# CITY OF ALBUQUERQUE

**Re: Juan Tabo Hills Unit 3A  
Grading and Drainage Plan  
Engineer's Stamp Date 4-3-13 (M22/D015)**

JUAN TABO HILLS UNIT - 3A
GRADING & DRAINAGE PLAN

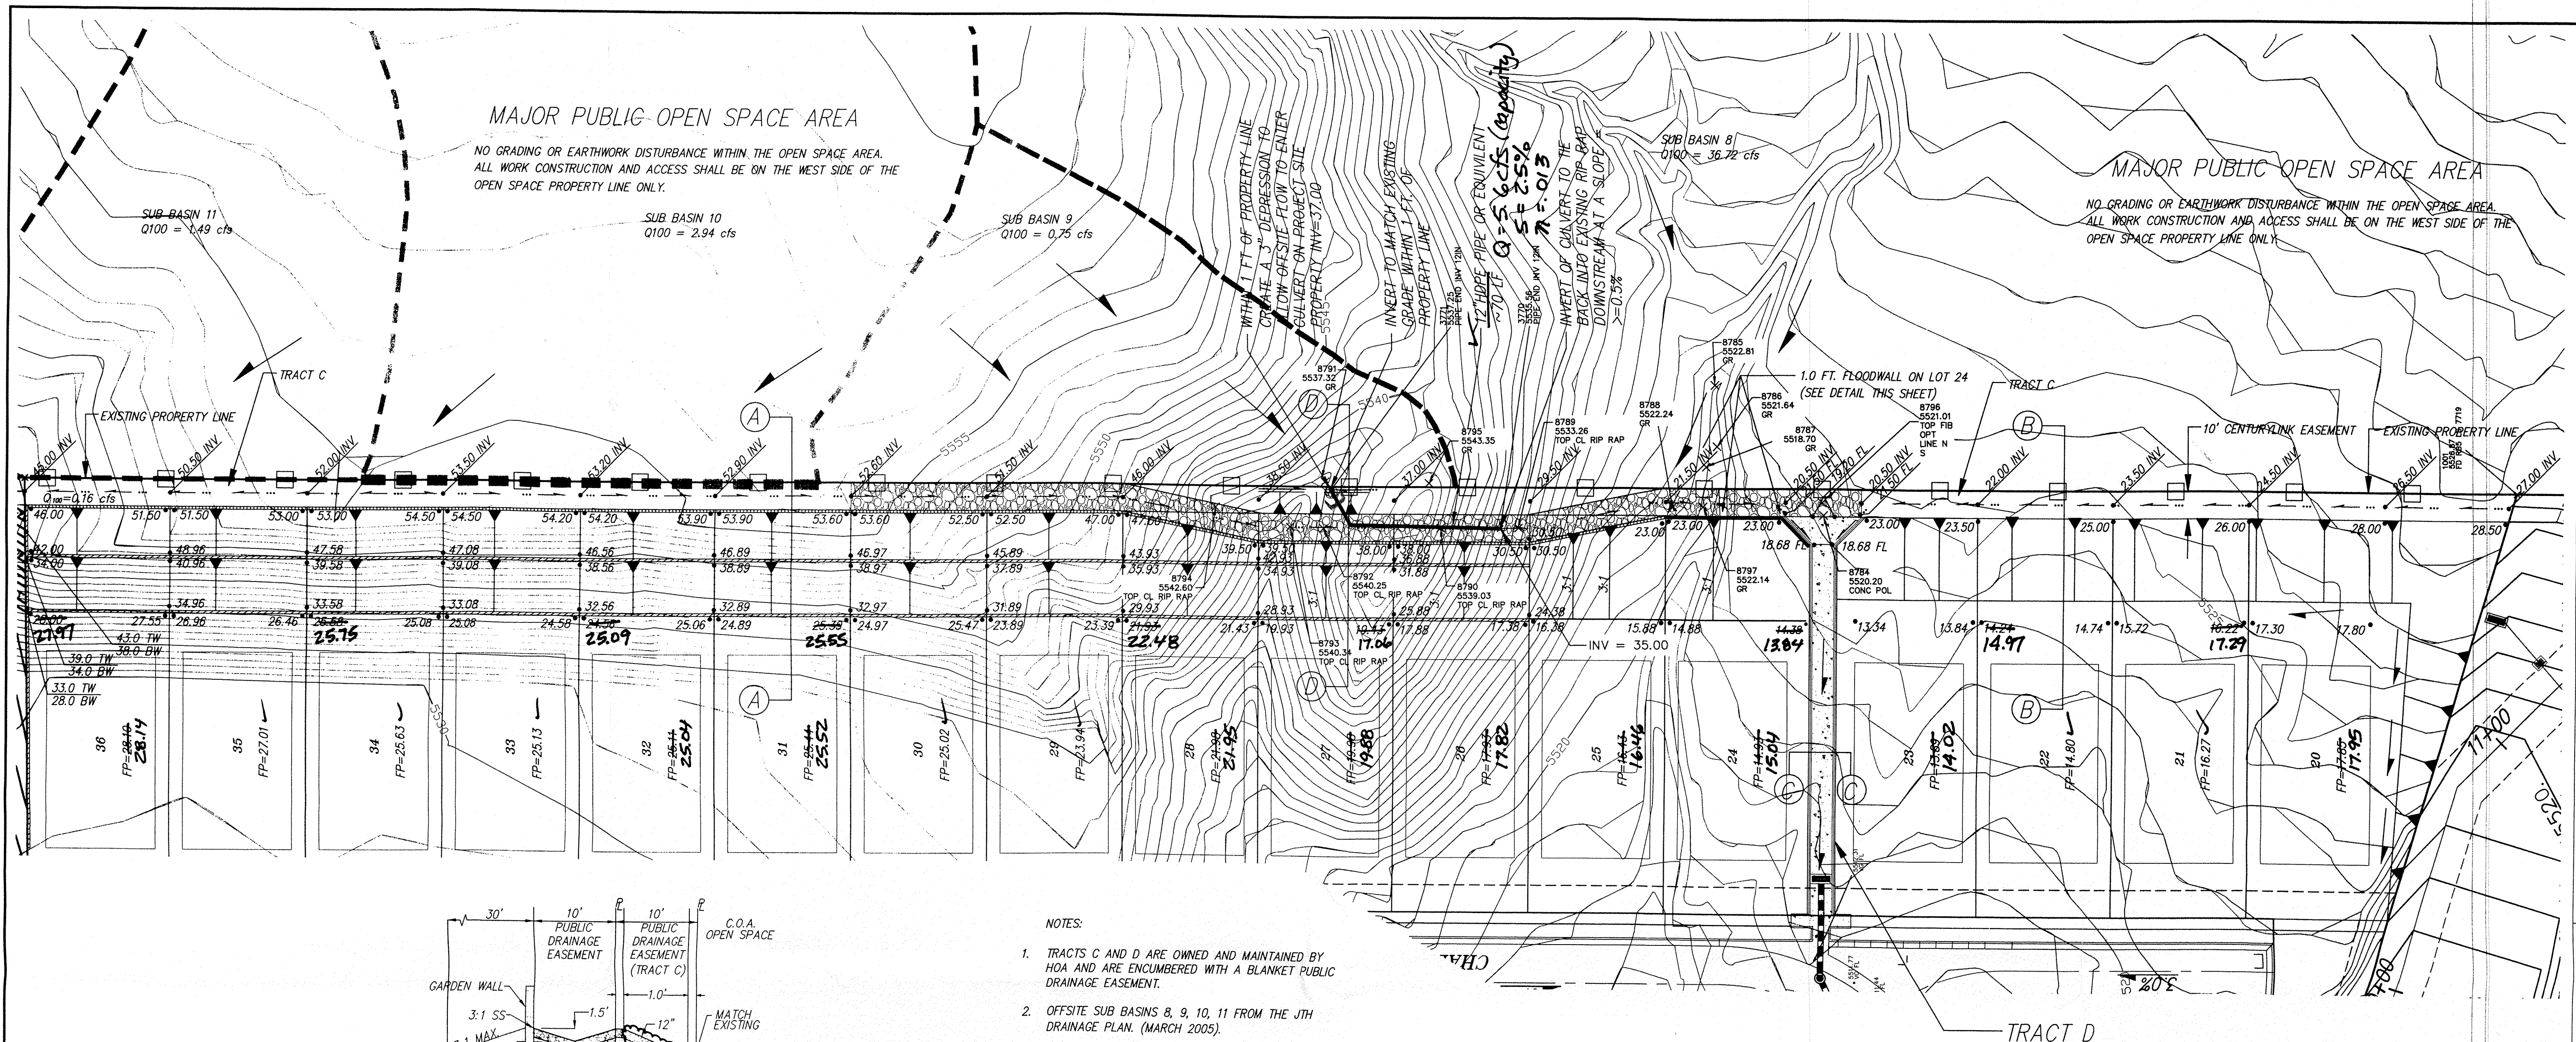
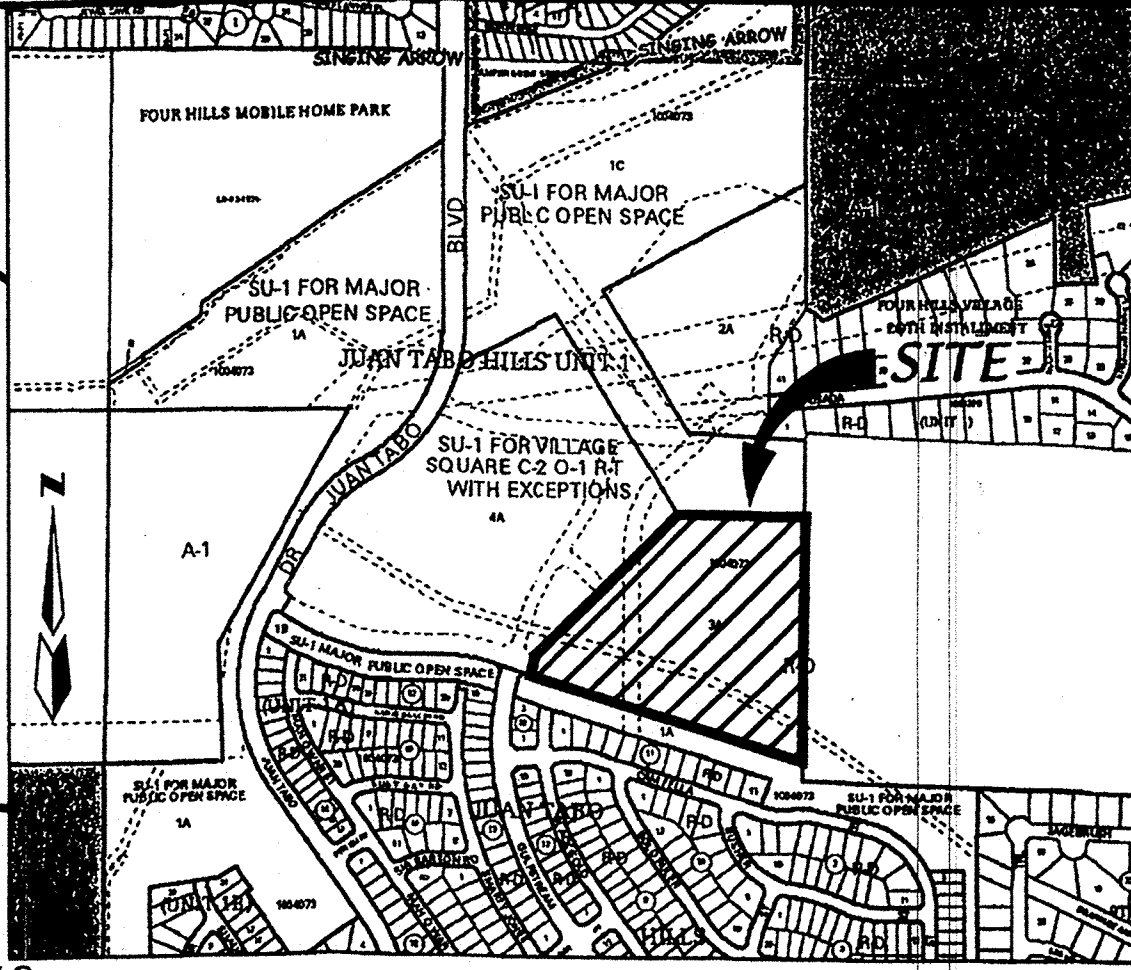
Based upon the information provided in your submittal received 4-29-13, the above referenced plan is approved for Grading Permit. Tract 1-C-2 is not part of this submittal. A letter of agreement from open space is required to grade in this area.

This is the plan to certify for Release of Financial Guarantee (ROFG) and Building Permit. At the time of ROFG, the effectiveness of the inlets to remove stormwater from the street should not be reduced by the use of SWPPP controls.
